1331/APP/2017/1883 - Former Nestle Factory , Nestles Avenue, Hayes,

Barratt London Residential Development

Flood Risk and Drainage

This note has been compiled in response to comments dated 3rd July 2017 from London Borough of Hillingdon Flood Risk Authority. The responses relate to the comments on the residential development only.

Drawing Title:  
**PROPOSED DRAINAGE STRATEGY SHEET 1**

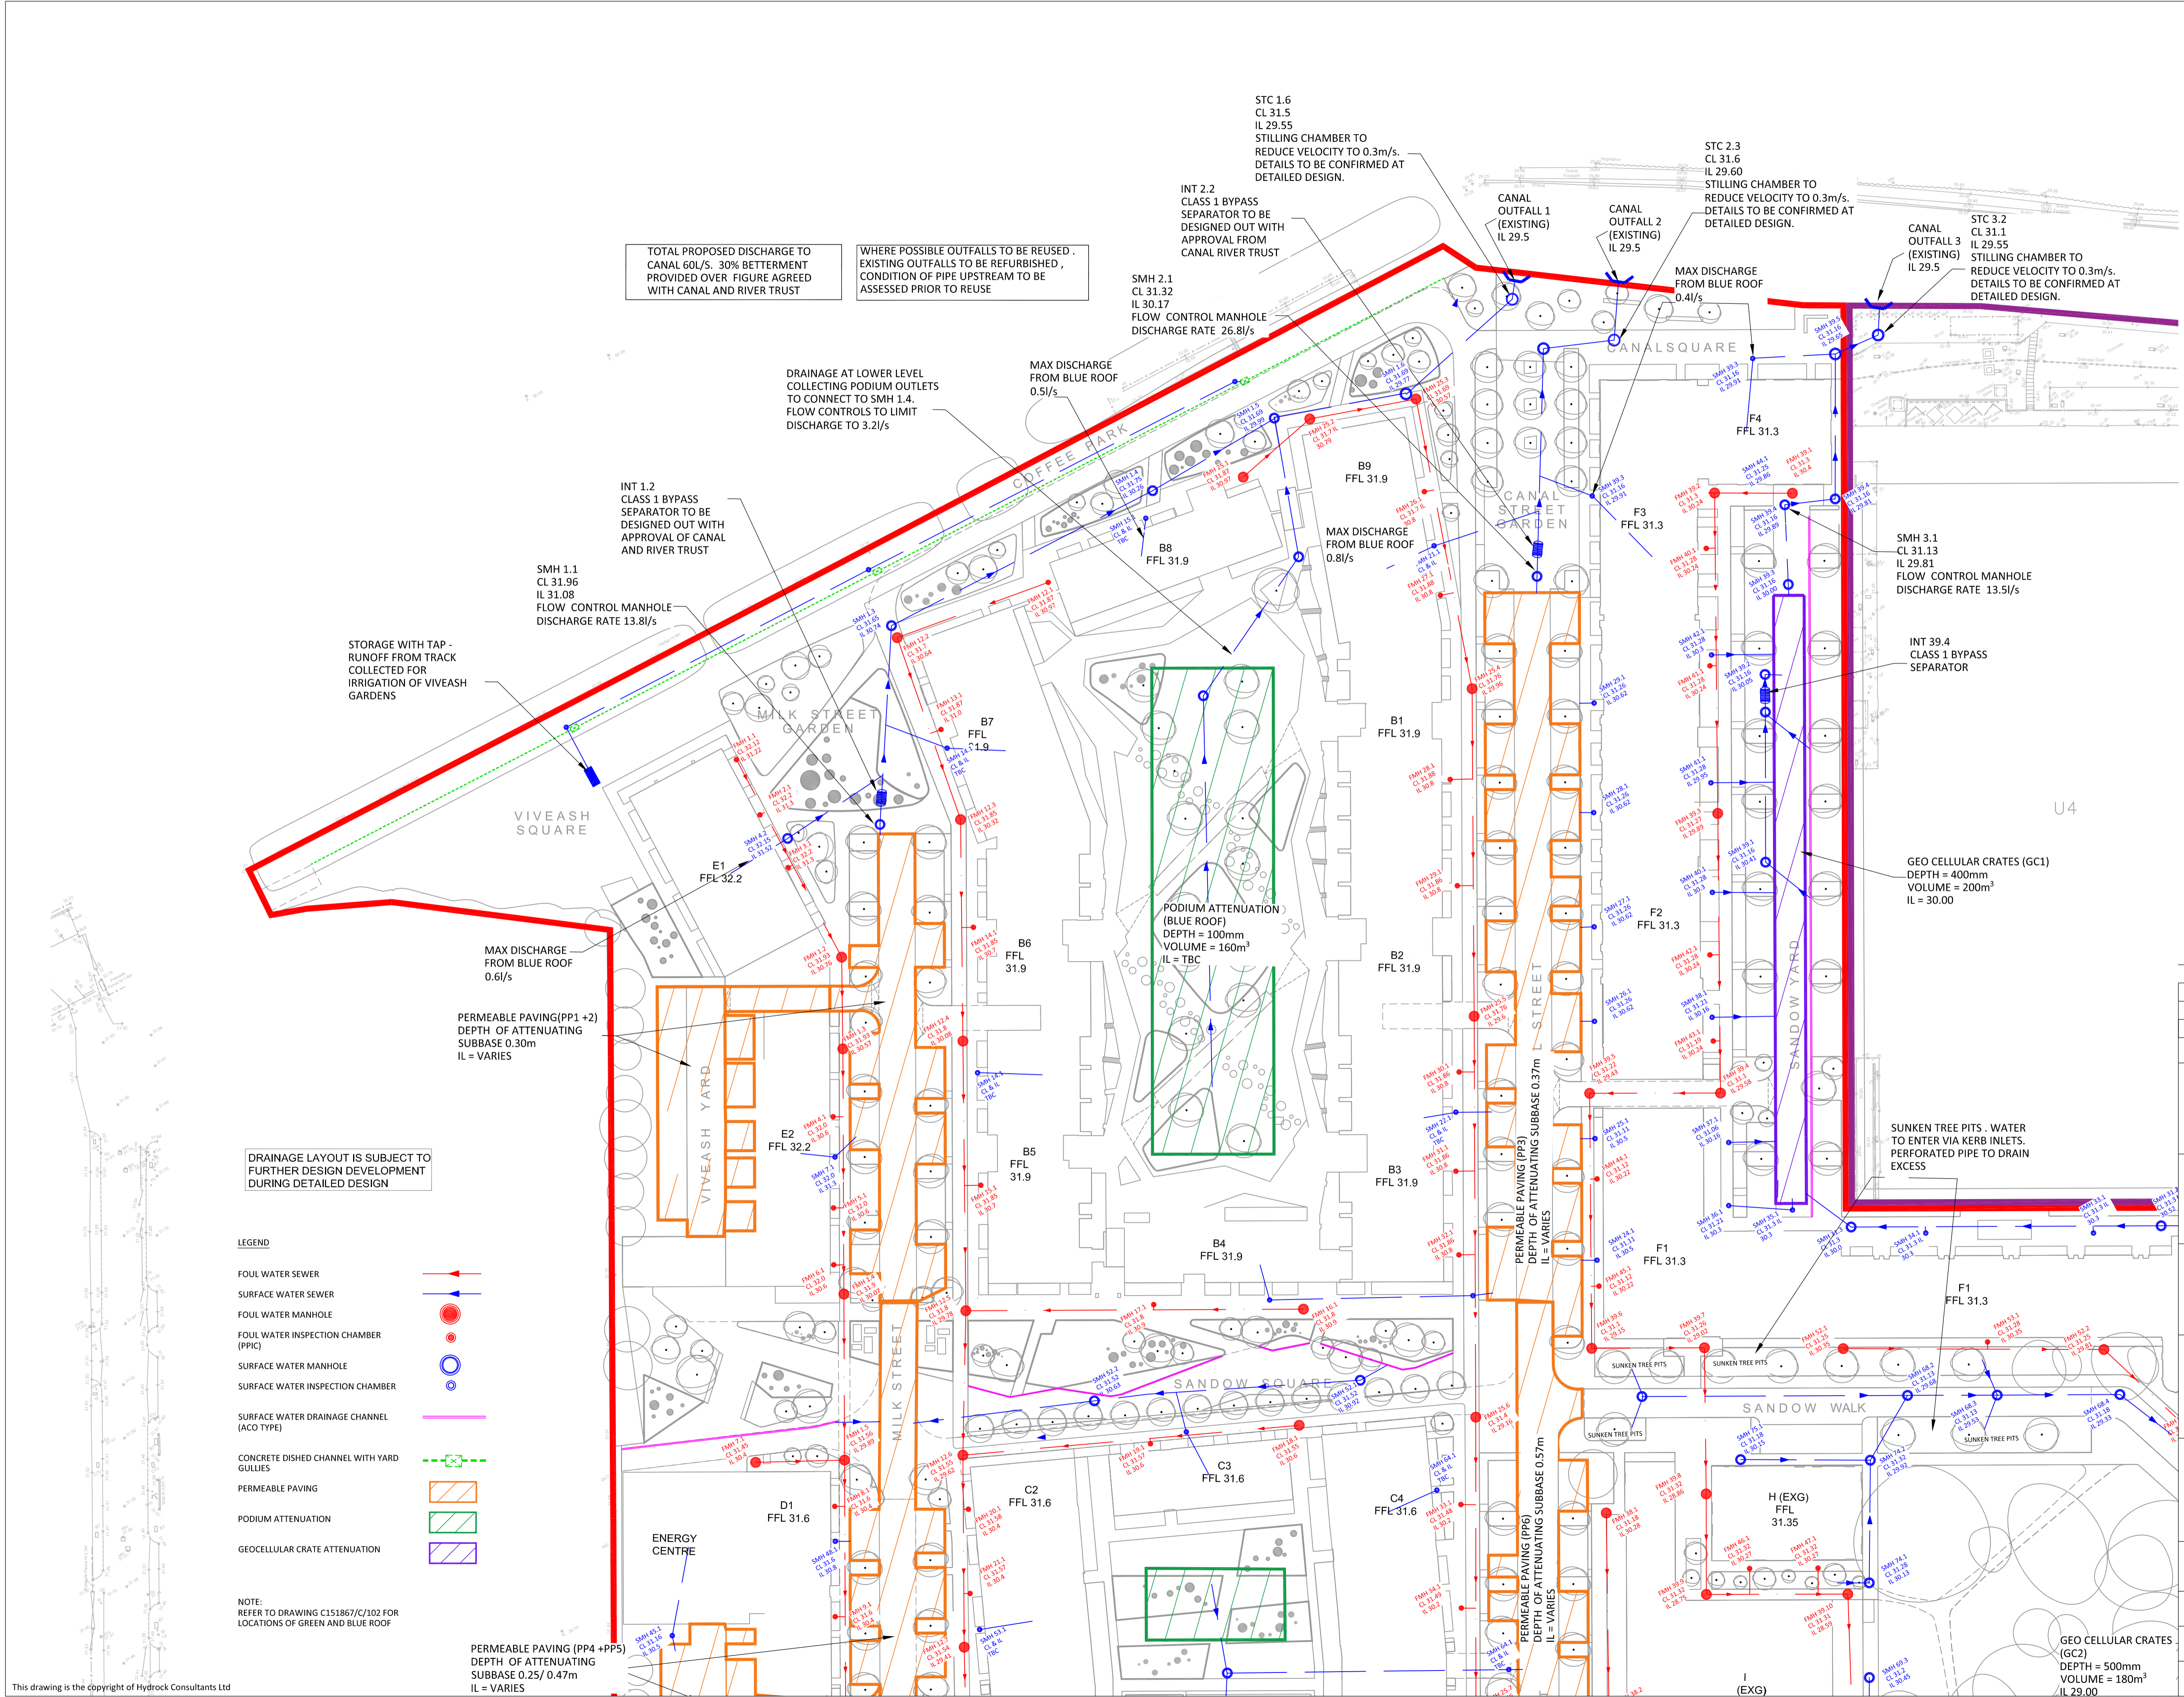
Please find attached the updated catchment area plans, C151867/C/100 P2 (Existing Drainage catchment areas), C151867/C/101 Rev P7 and C151867/C/104 Rev P3 (Proposed drainage catchment areas).

The catchment area plans demonstrate how the existing catchments that drain to Nestle Avenue and the canal compare to the proposed catchments to these areas.

i.e. the existing catchment to Nestle Avenue is 35,229m². The proposed catchment to Nestle Avenue is 20,027m². The proposed catchment to Nestles Avenue is therefore reduced. The existing catchment to the canal is 36,282m², the proposed catchment is 20,743m² which again is significantly reduced from the existing.

Where areas can be drained to verges or permeable landscaping these have been excluded from the proposed catchment plans.

There are three existing outfalls into the canal located with the Barratt site. Where possible we shall retain and reuse existing outfalls into the canal. Within the next stage of the design works the length of existing pipe which leads to the outfalls shall be surveyed for condition. Where the condition deems the pipe to not be reusable the pipe shall be replaced. As a minimum we would expect to need to refurbish the flap valves for each retained outfall to ensure it's in good working order. The existing pipe diameter / or angle to the canal

may also require the pipe to be replaced if it is not suitable. This is something which shall be worked through during the next stage of design. The current design is based on the existing invert level of the outfalls.

The drainage layout also shows a number of connections into the Thames Water sewers in Nestles Avenue for both the surface water and the foul water. These generally connect via an existing manhole, apart from one location where a new manhole shall be constructed to allow the connection.

In line with your comments we have recalculated the proposed discharge rate to the Thames Water Sewers for the site based on 1 x the greenfield runoff rate.

The proposed discharge rate shall therefore be 44.5l/s for a 1 in 100 year +40% CC event.

The proposed discharge rate to the canal was based on the calculation method stipulated by Canal and River Trust which allows the discharge to match the existing flows. Recent correspondence with the CRT shows that they are happy with this and that their risk assessment shows there to be no detrimental effect due to the canal working as a form of attenuation (correspondence is attached) . However, we propose a 30% betterment of the existing flow. The proposed discharge rate shall therefore be 60l/s.

To account for the additional attenuation required following the revision of the discharge rates we have extended the use of SUDS within the site.

In response to the LBH comments blue roofs have been added to the new blocks. This shall work in combination with the green roofs to store water, some of which will be lost through evaporation and transpiration, the remainder shall be released at a limited rate. A blue roof remains within the podium landscaping.

Permeable paving remains within the roadways and most parking areas. Within Sandow Yard we are proposing to use below ground crates. The rear portion of Block F1 is to drain to the canal via this attenuation,
